Our Ref: R/2020/11/A
File No: 2020/406675
Your Ref: SSD-10454

Karl Fetterplace
Senior Planner, Key Sites Assessments
Department of Planning, Industry and Environment

Request for Advice - Intercontinental Hotel - Stage 2 (SSD-10454)

Figure 1 Wall mounted bicycle parking layout

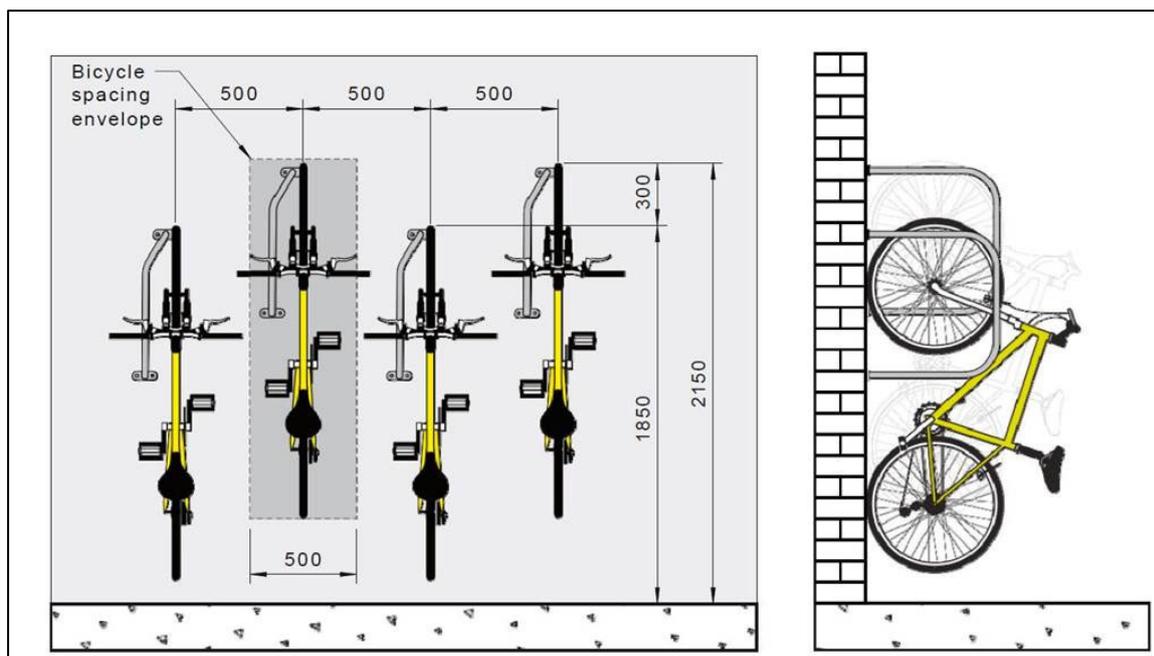
It is recommended that at minimum, bicycle parking be increased to accommodate additional spaces reflecting the projected staff member increase. This will result in a total of 18 bicycle spaces being the 5 existing spaces plus 13 in accordance with the staff bicycle parking rates in the Sydney DCP 2012. The location of the additional bicycle spaces should be in close proximity to existing spaces and end of trip facilities. It is recommended that existing car spaces can be utilised for bicycle storage if they cannot be accommodated elsewhere.
